**RE: Santa Barbara Arsenic Treatment Facility
3301 Claremont Ave NE
Grading and Drainage Plan
Engineer's Stamp Date: 08/12/2025
Hydrology File: H16D100
Case # HYDR-2025-00291**

Based upon the information provided in your submittal received 08/12/2025, the Grading & Drainage Plans are not approved for Building Permit. The following comments need to be addressed for approval of the above referenced project:

ENGINEER'S SEAL		ALBUQUERQUE BERNALILLO COUNTY WATER UTILITY AUTHORITY	
 08/12/2025		TITLE: SANTA BARBARA ARSENIC TREATMENT FACILITY DRAINAGE PLAN - HYDROLOGY	
		WATER AUTHORITY CONSTRUCTION PROJECT NO.	2308.010
		ZONE MAP NO.	H-16-Z
		SHEET	C-14A

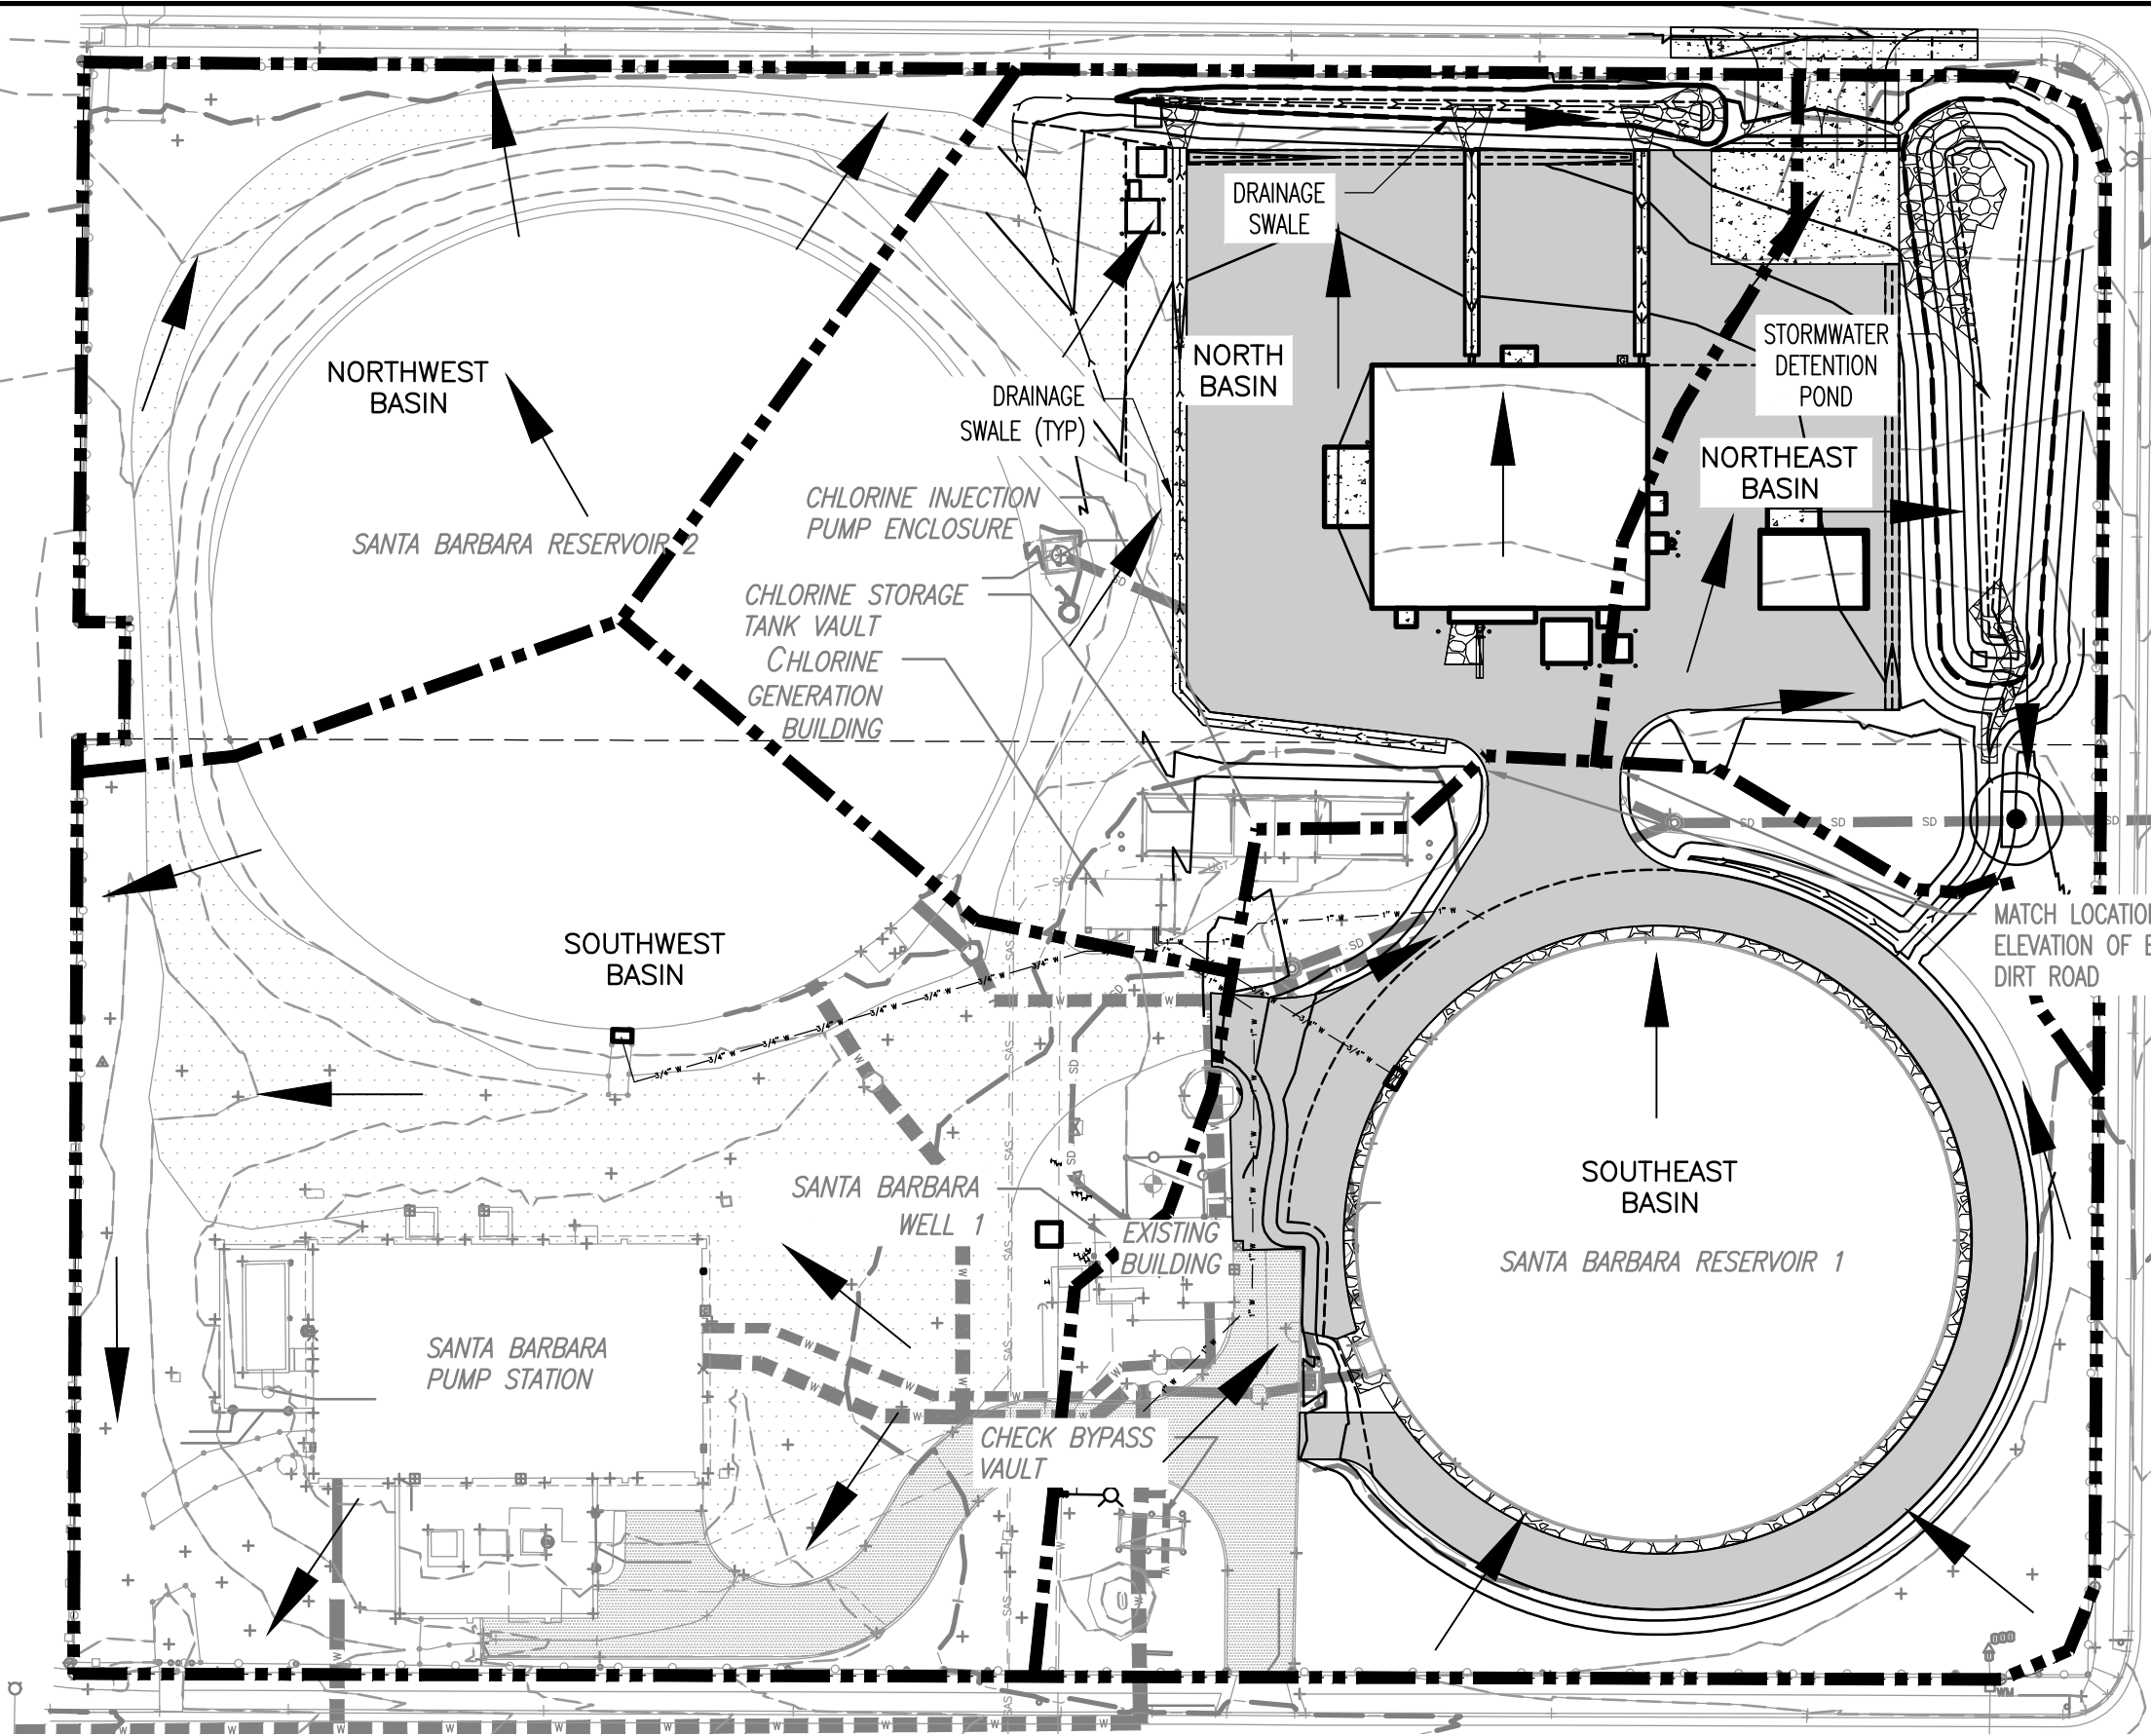
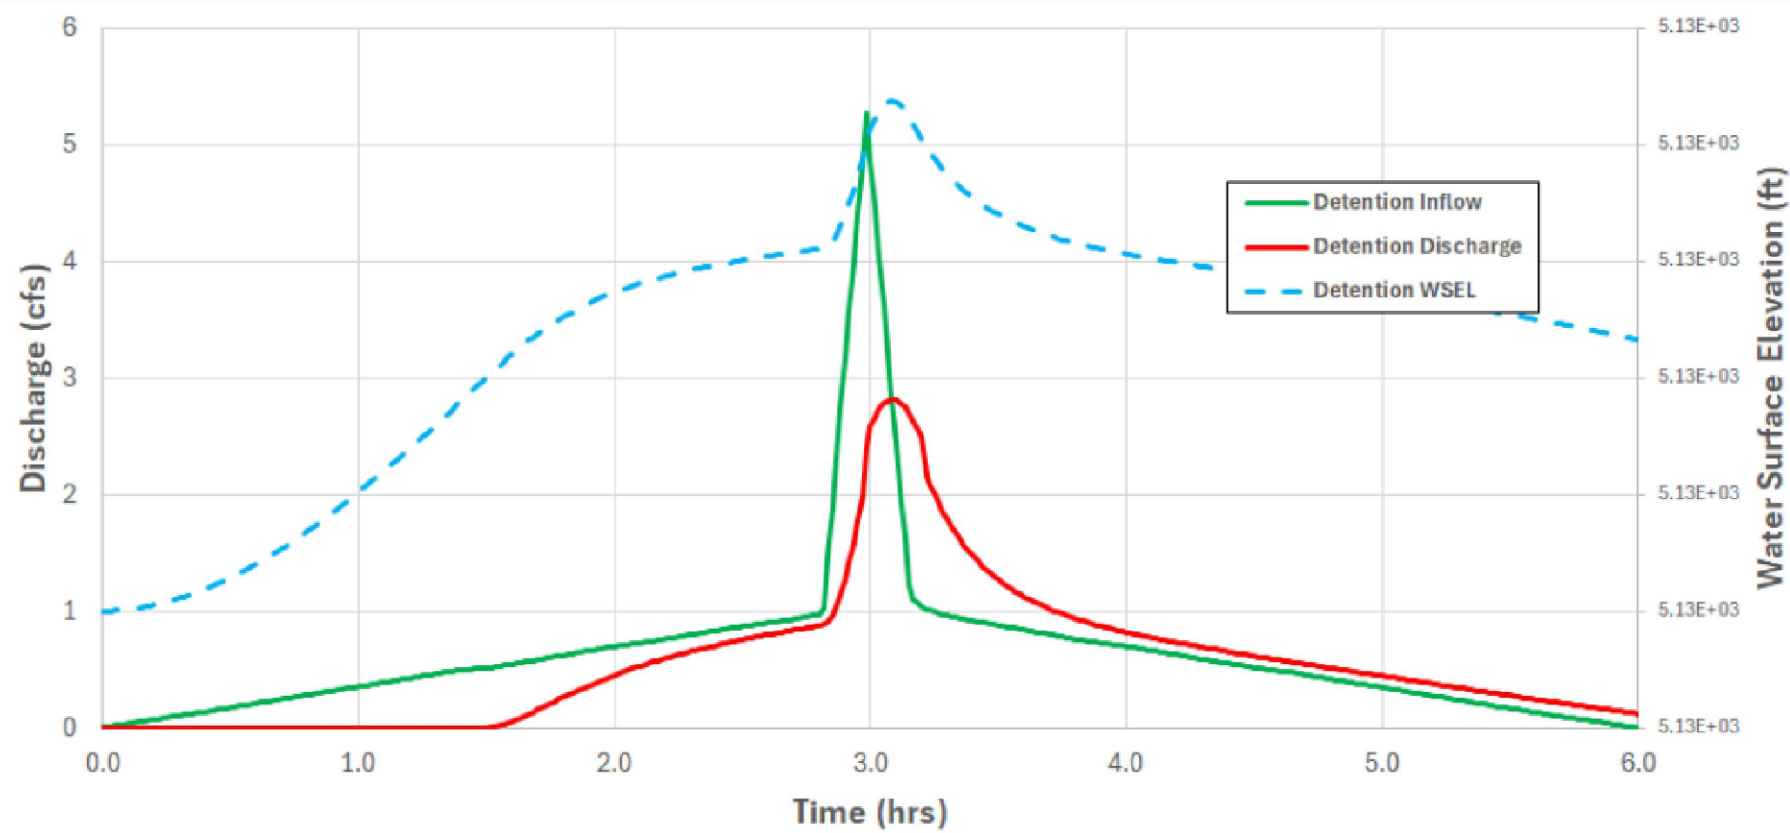
1. Please provide the FIRM Map and floodplain note with effective date.
